DECISION DELEGATED TO HEAD OF PLANNING

Application No: H14-0625-24 **Applicant:** Harlaxton Estates Limited

Proposal: Details of Biodiversity Net Gain Plan (Condition 6 of H14-1135-23)

Location: Land Off Bervor Close Wardentree Lane Pinchbeck

drawing
BIO-DIVERSITY NET GAIN PLAN

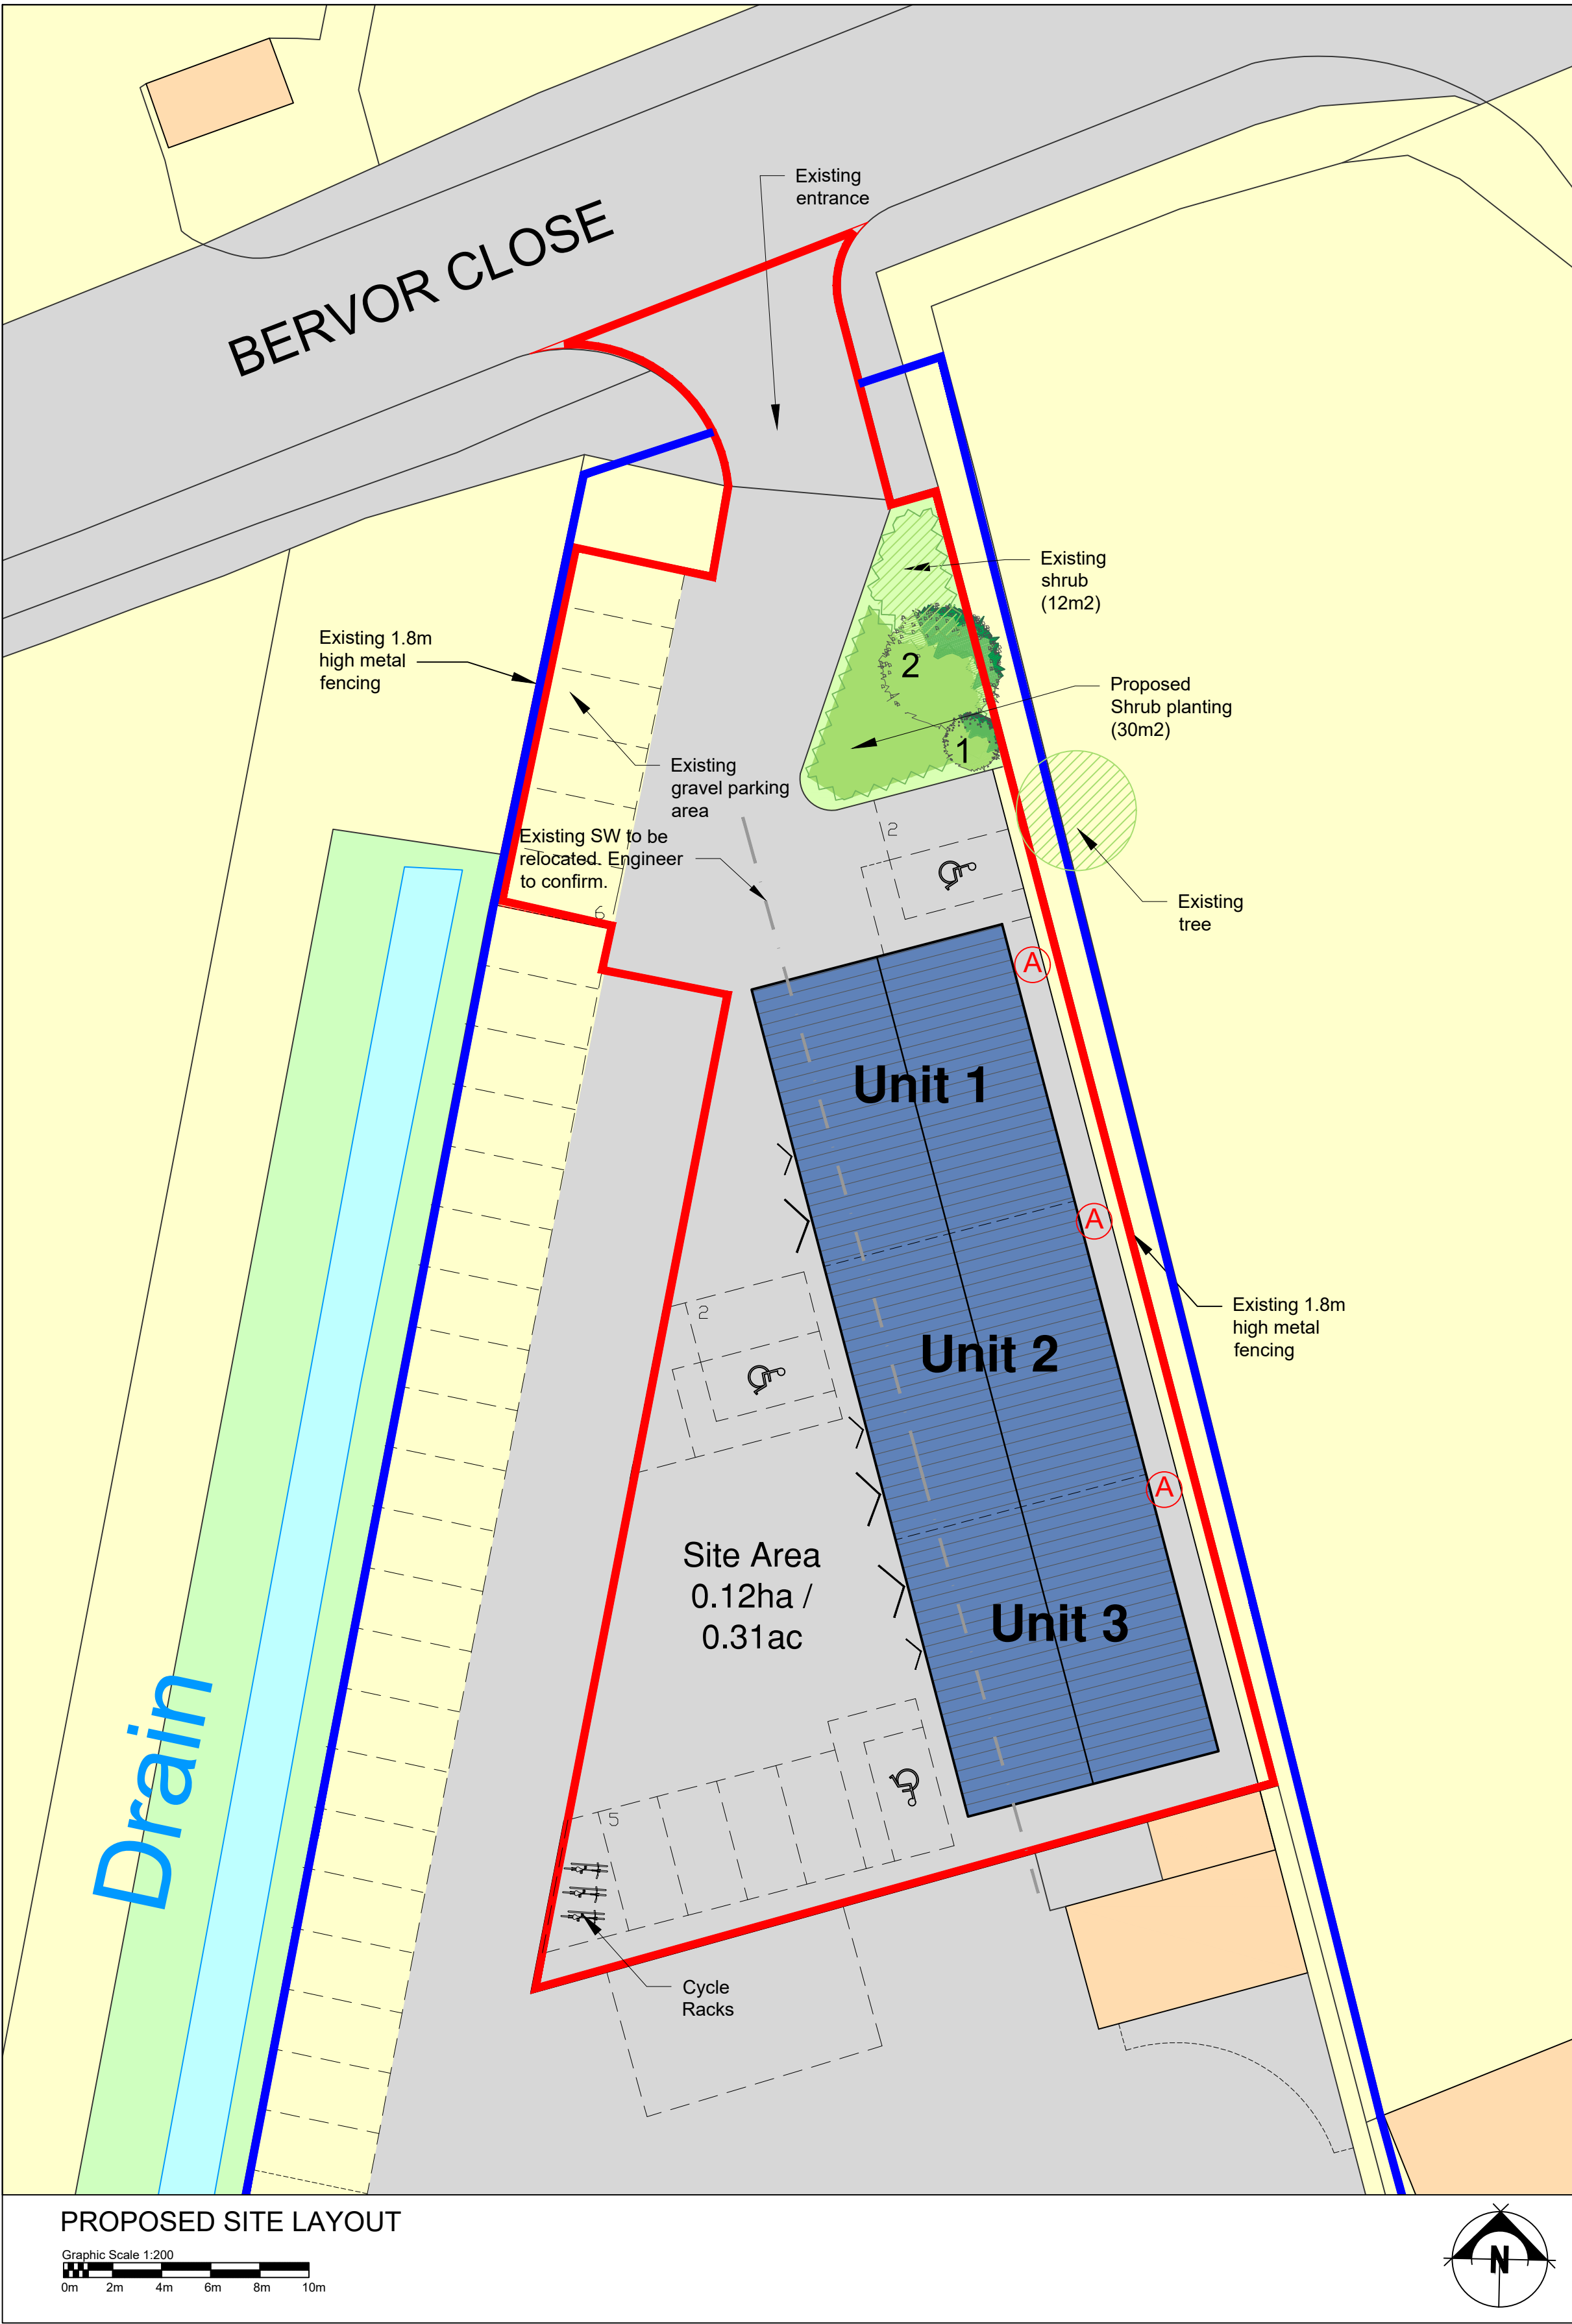
Due to the very limited scope for achieving biodiversity gains on this site, I would suggest the submitted BNG plan is acceptable. Obviously, there would be more that could be accomplished for biodiversity on the site with the addition of a green roof, but since this application came in before 10% BNG was mandatory and the site was previously developed, then I would judge that the BNG plan meets the 10% gain requirement.

The Parish Council feels that the proposed plan is disappointing and does not go far enough to enhance local biodiversity.

The site is an unused area of hardstanding with limited opportunity for biodiversity enhancement. The measures include soft landscaping to the gravel area to the northern end of the site adjacent to the main access from Bervor Road. 2 new native trees would be added.

3 new swift nesting boxes are to be added to the eastern building elevations. The swift boxes need to be checked annually.

The comments of the Parish Council that they are disappointed about how much has been provided are noted, however the Senior Ecologist recognises that this proposal was submitted prior to BNG being mandatory, and therefore it is not considered that further measures could reasonably be insisted upon.

The proposals are considered acceptable. Discharge condition 6.
